City of Albuquerque

RE: ENGINEER'S CERTIFICATION FOR UNM BUSINESS PARK, TRACT 1 (N-157D6A)
RECEIVED JANUARY 31, 1994 FOR CERTIFICATE OF OCCUPANCY APPROVAL
STAMPED & DATED 1-27-94

RE: ENGINEER'S CERTIFICATION FOR UNM BUSINESS PARK, TRACT 1 (N-157D6)2
RECEIVED JANUARY 12, 1994 FOR CERTIFICATE OF OCCUPANCY APPROVAL
STAMPED & DATED 1-10-94

GRADING & DRAINAGE PLAN

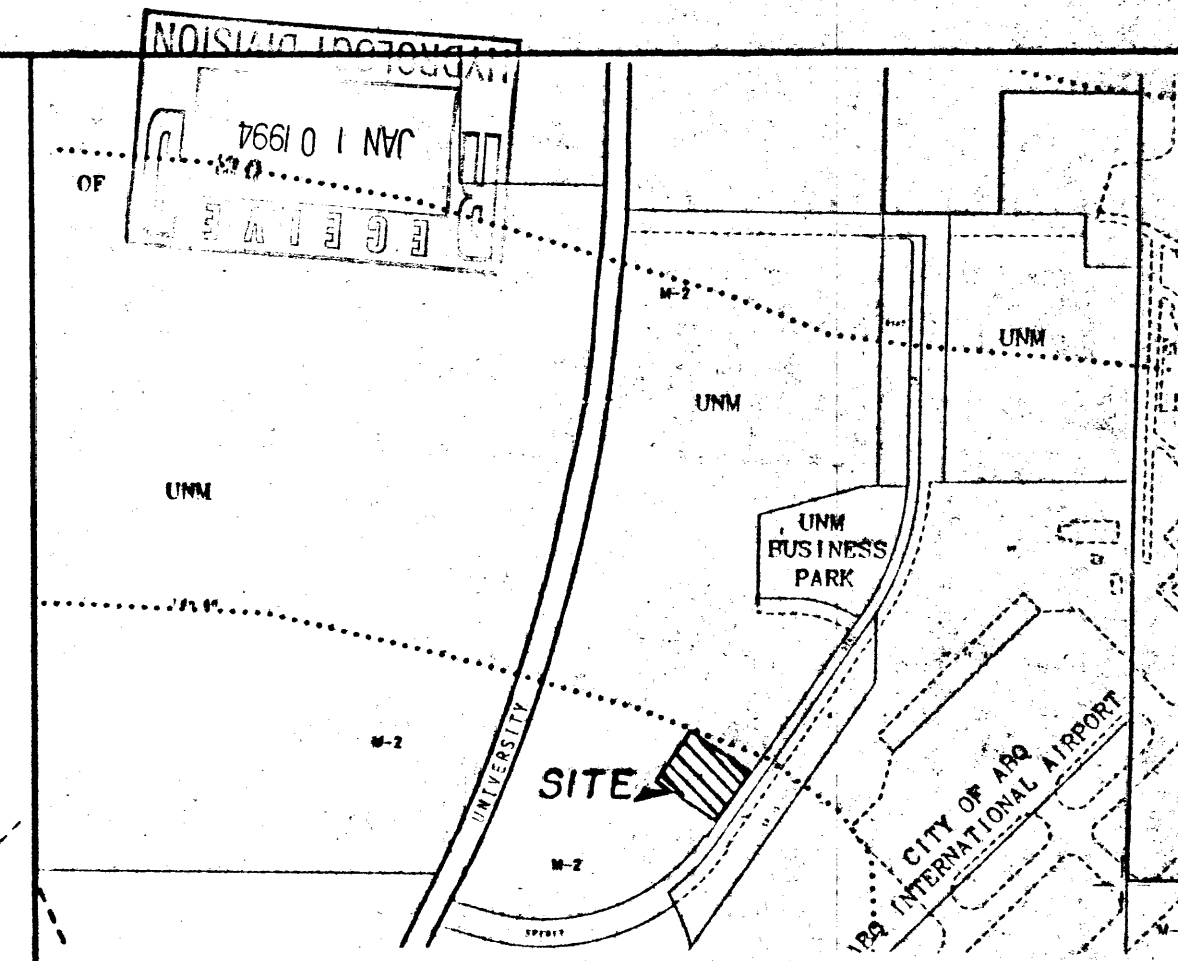
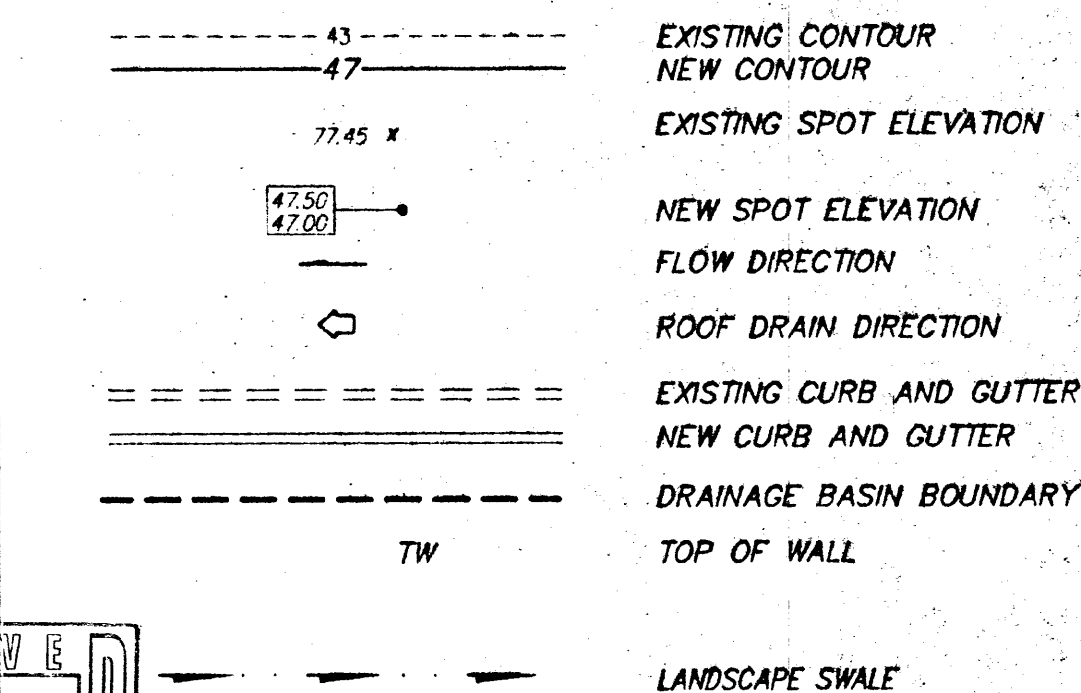
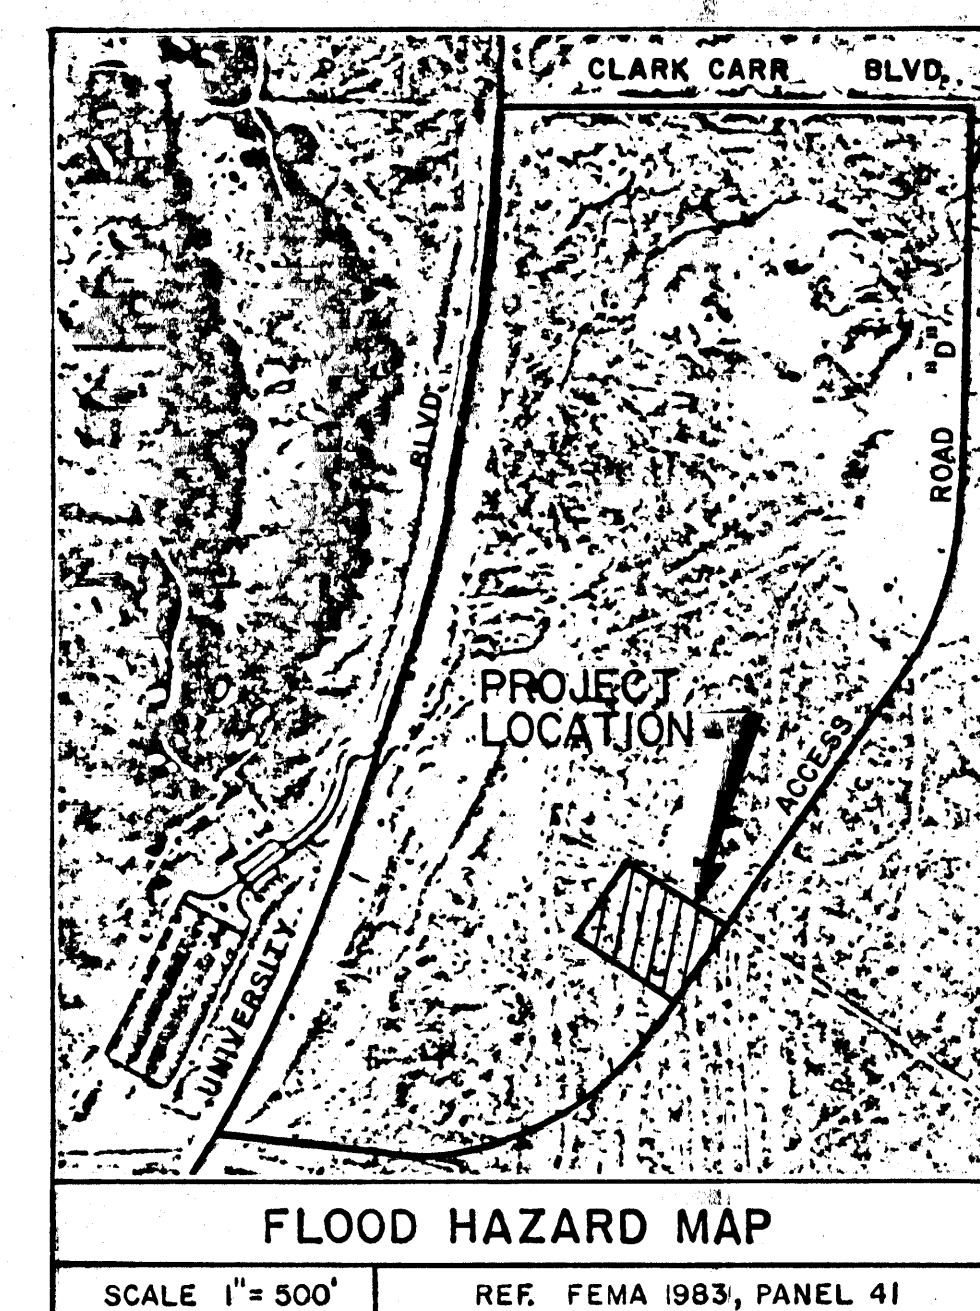
1. The file for this project indicates that the approved Grading & Drainage Plan was dated 1-27-93 and that the Plan dated 9-24-93 was not reviewed. Therefore the as-built elevations need to be compared to the elevations shown on the Plan dated 1-27-93. The best way to do this is to put a line through the proposed elevations that have changed and indicate the as-built elevation next to the proposed. If the as-built elevation is exactly the same as the proposed it is sufficient to put a check mark by it.
2. The DPM checklist requires that the Engineer certify substantial compliance with the approved Plan not close compliance. If there have been changes, then the Engineer must explain why they were made.
